## Architect's Supplemental Instructions

**PROJECT** (Name and address):  
Bangor Savings Bank - Marginal  
Way  
20 Marginal Way, Portland, Maine

**ARCHITECT'S SUPPLEMENTAL  
INSTRUCTION NO:** 003

**DATE OF ISSUANCE:** September 23, 2015

GI002

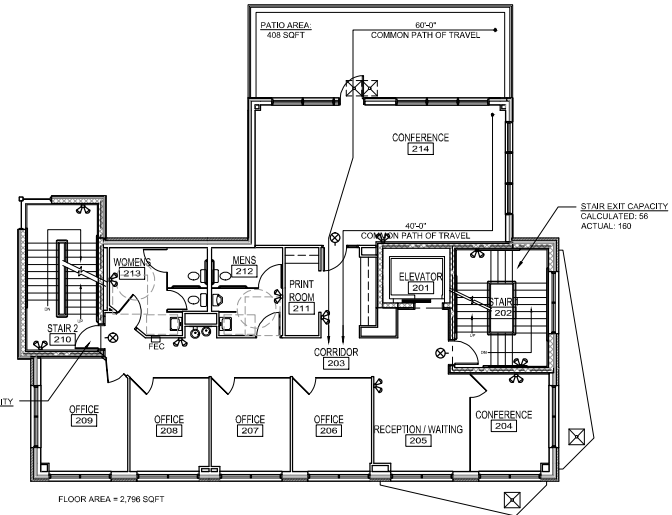
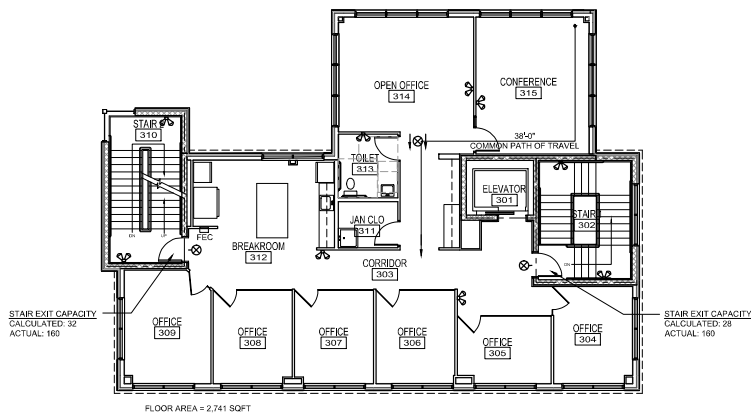
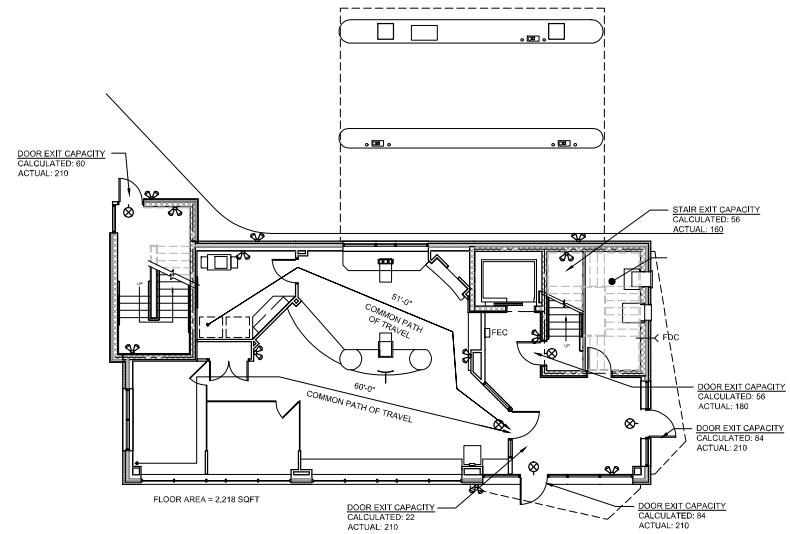
GI002 and GI003- updated to address the penthouse and exterior fire rated walls.

**K4** C02 - 8" CMU BLOCK WALL w/ 2 1/2" METAL STUDS  
3/8" = 1'-0"

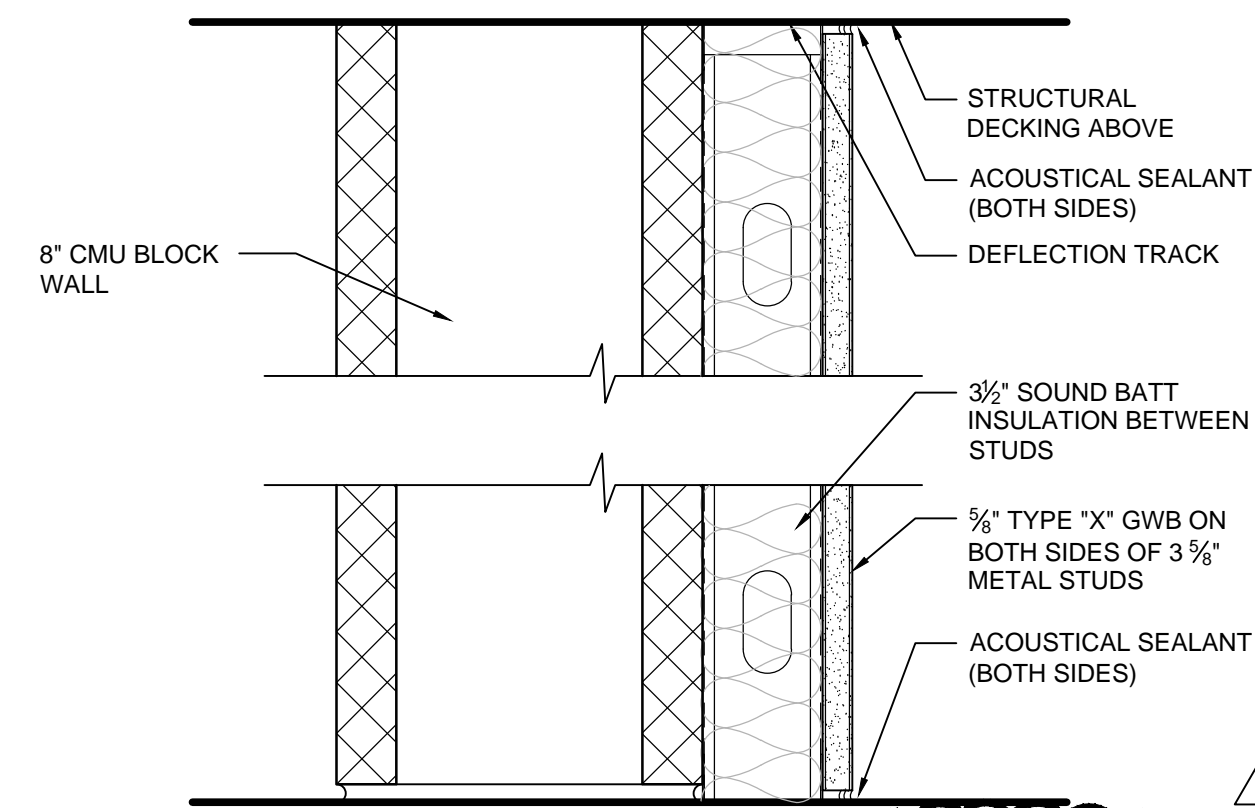
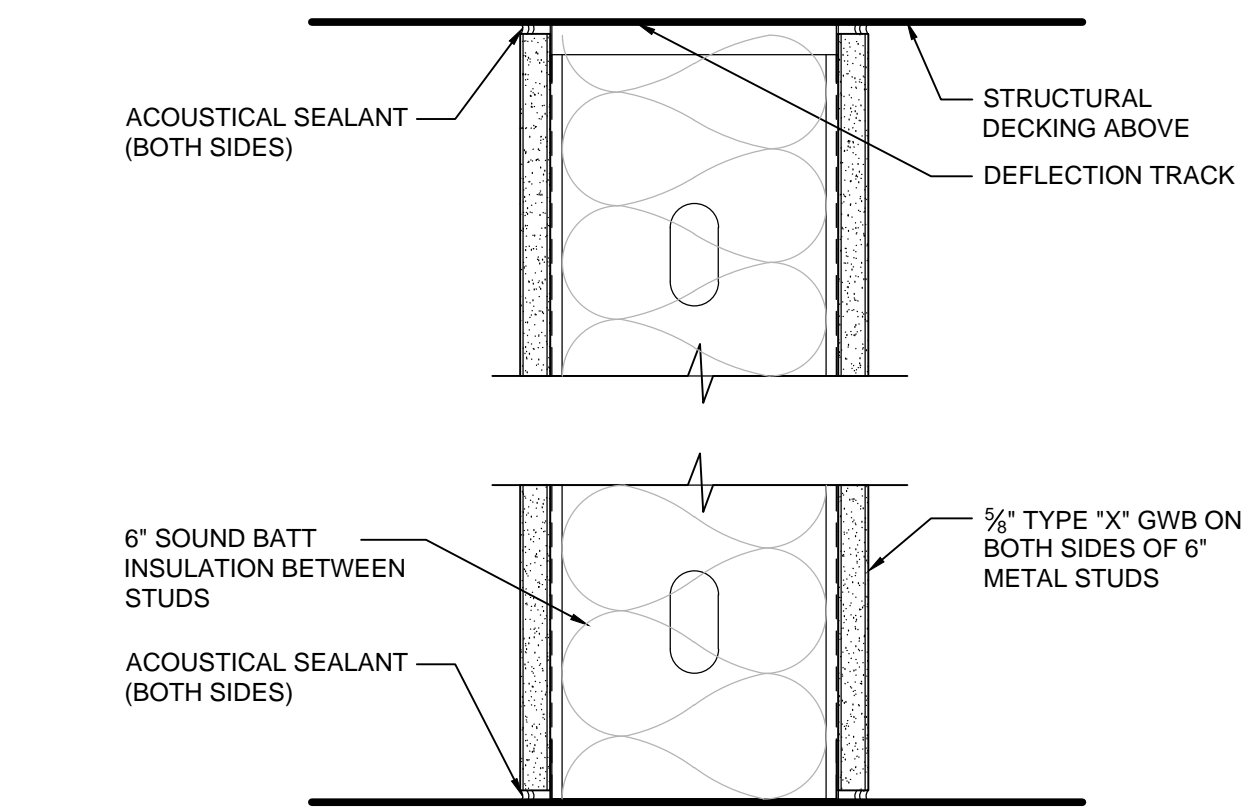
AE502 Partition Types add 1 hour rating to K4 and A8.

AE203

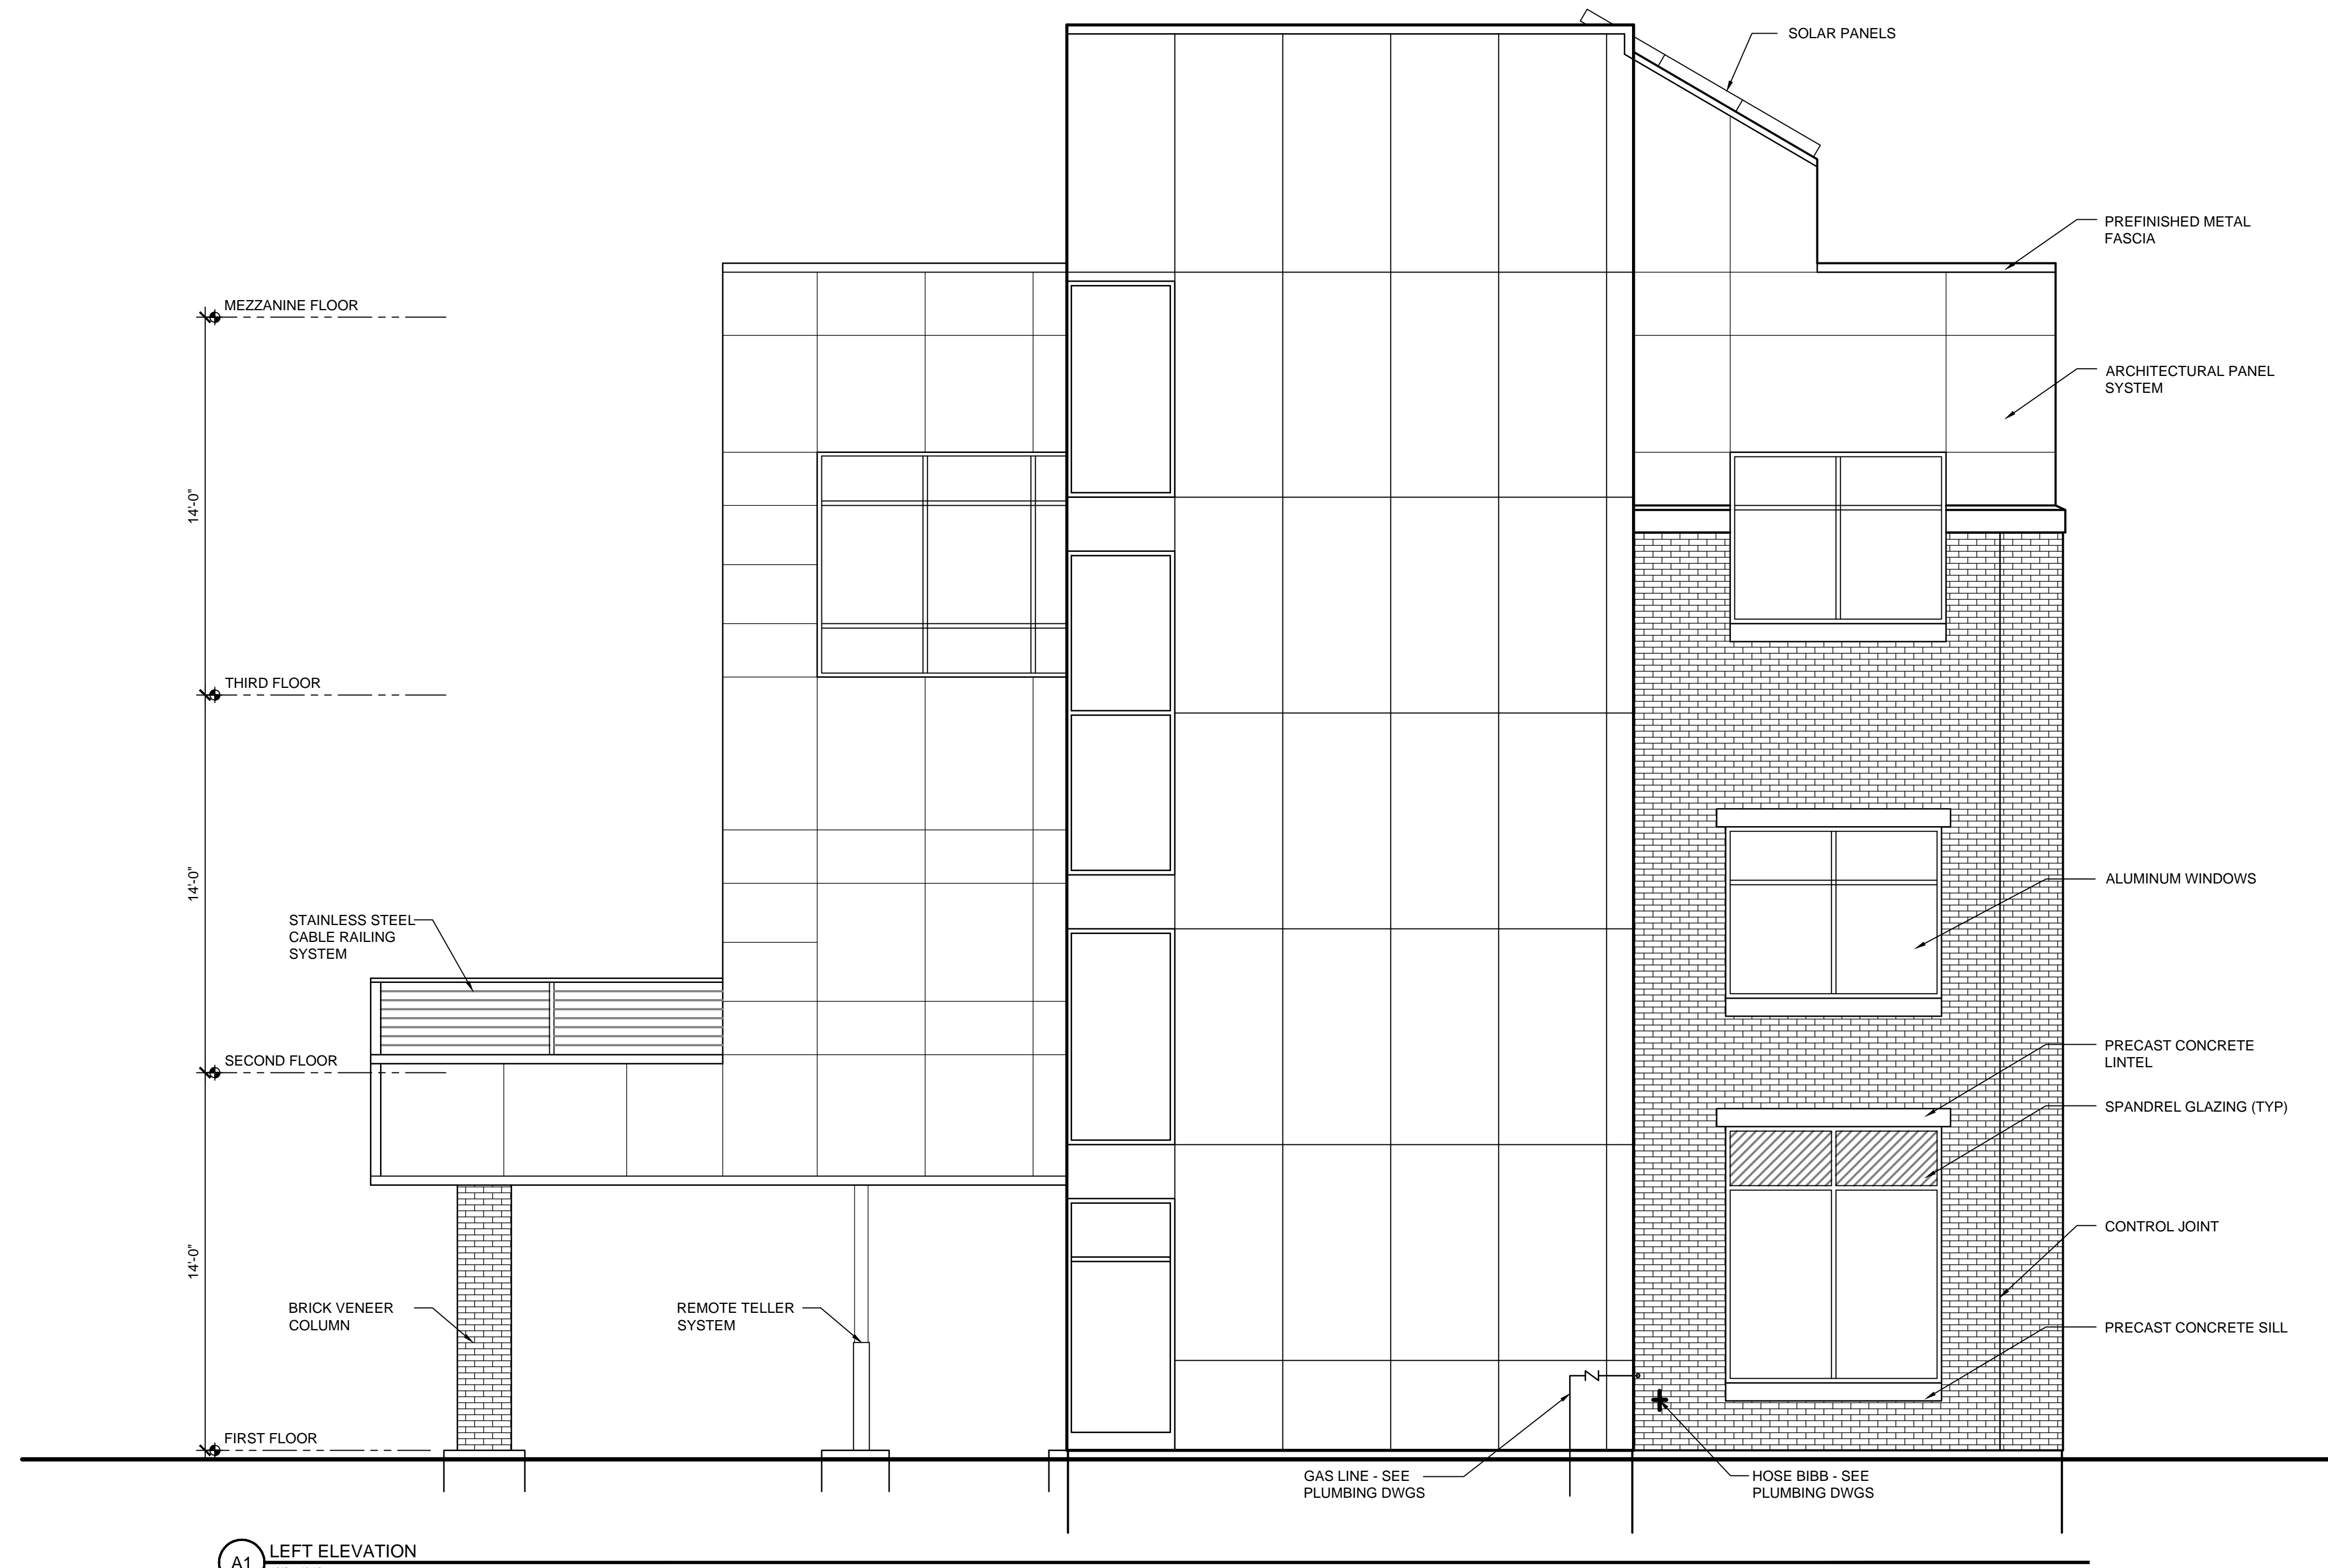
AE203 & AE204 Exterior Elevations revised window location and size
